Section 96(1A) Modification Application Environmental Assessment

For:
Faculty of Arts and Social Sciences (FASS),
University of Sydney

SSD 7081

August 2017

drawing ROOF PLAN

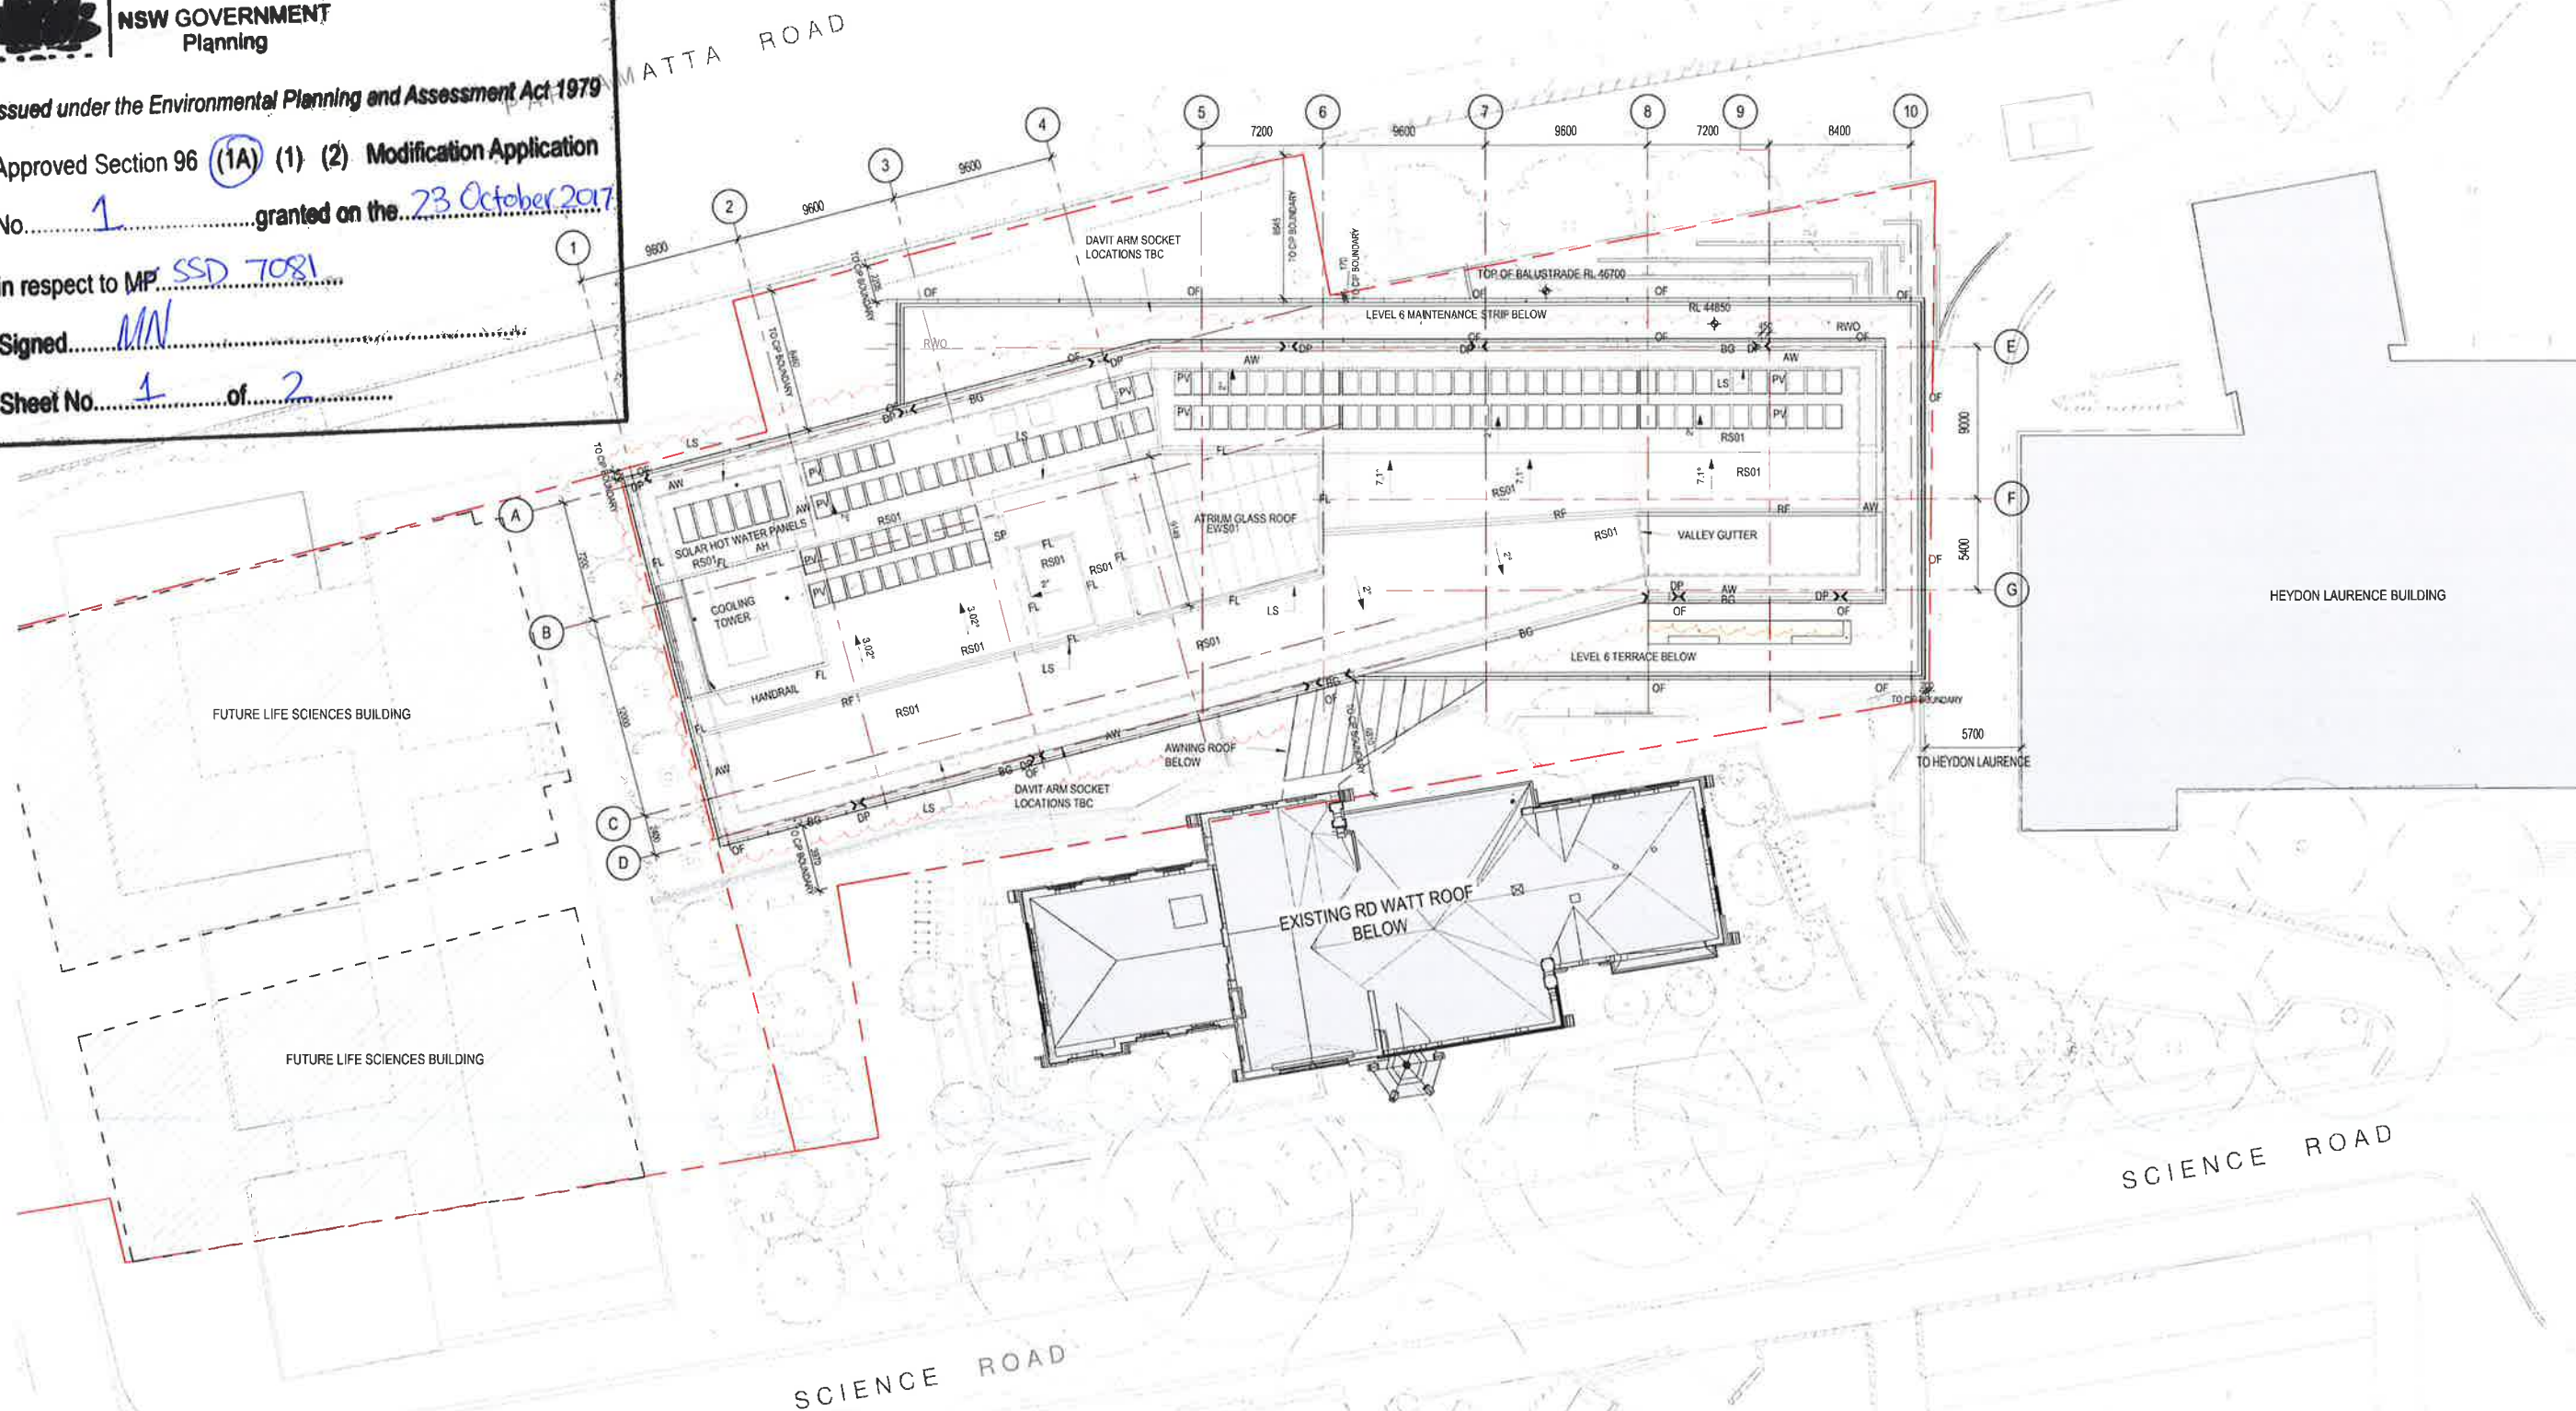
- *Change of roof sheeting colour from Colorbond 'Gully' to Colorbond 'Surfmist' to achieve compliance with the University of Sydney's mandatory ESD framework requirements;*

In summary, it has become apparent that the approved metal roof sheeting colour, Colorbond 'Gully' will not achieve the necessary Solar Reflectivity Index (SRI) to comply with the requirements of the University's Sustainability Framework. To comply, it is necessary to change the colour of the roof sheeting to Colorbond 'Surfmist' which provides a much higher Solar Reflectivity Index (SRI).

As detailed design has progressed, it has become apparent that the DA approved metal roof sheeting colour, Colorbond 'Gully' will not achieve the necessary Solar Reflectivity Index (SRI) to comply with the requirements of the University's Sustainability Framework. To comply, it is necessary to change the colour of the roof sheeting to Colorbond 'Surfmist' which provides a much higher Solar Reflectivity Index (SRI).

drawing
PROPOSED EXTERNAL FINISHES

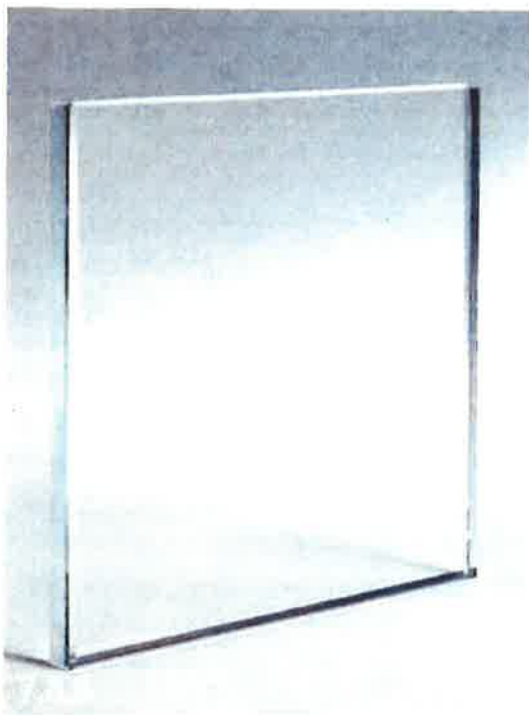
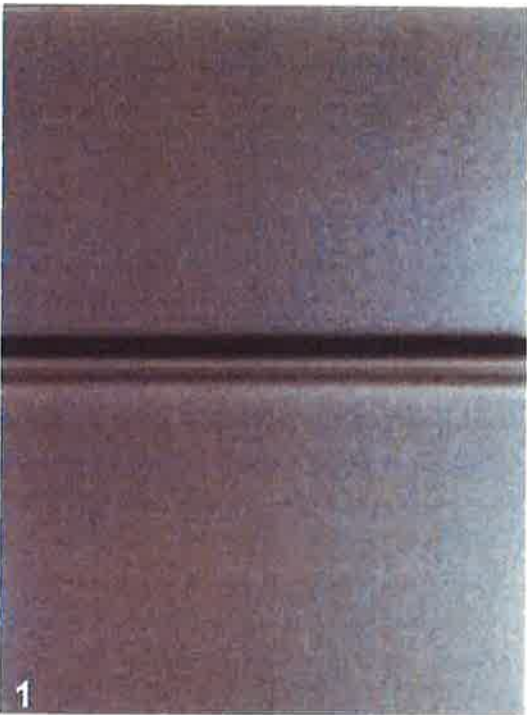
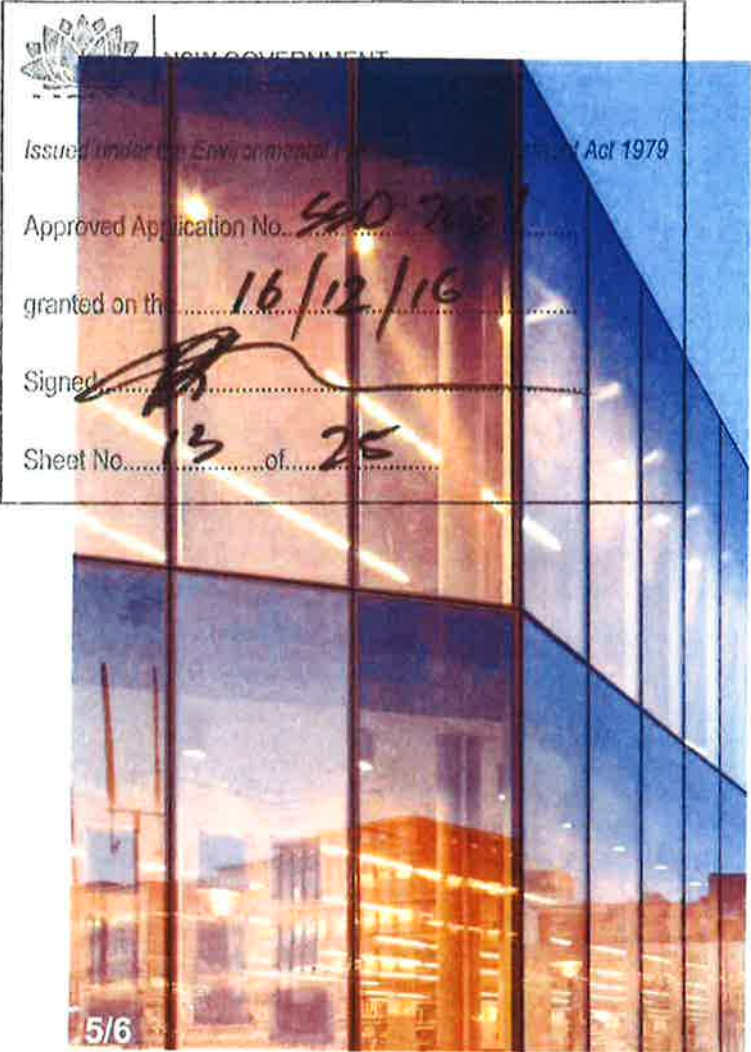
- *Change of roof sheeting colour from Colorbond 'Gully' to Colorbond 'Surfmist' to achieve compliance with the University of Sydney's mandatory ESD framework requirements;*
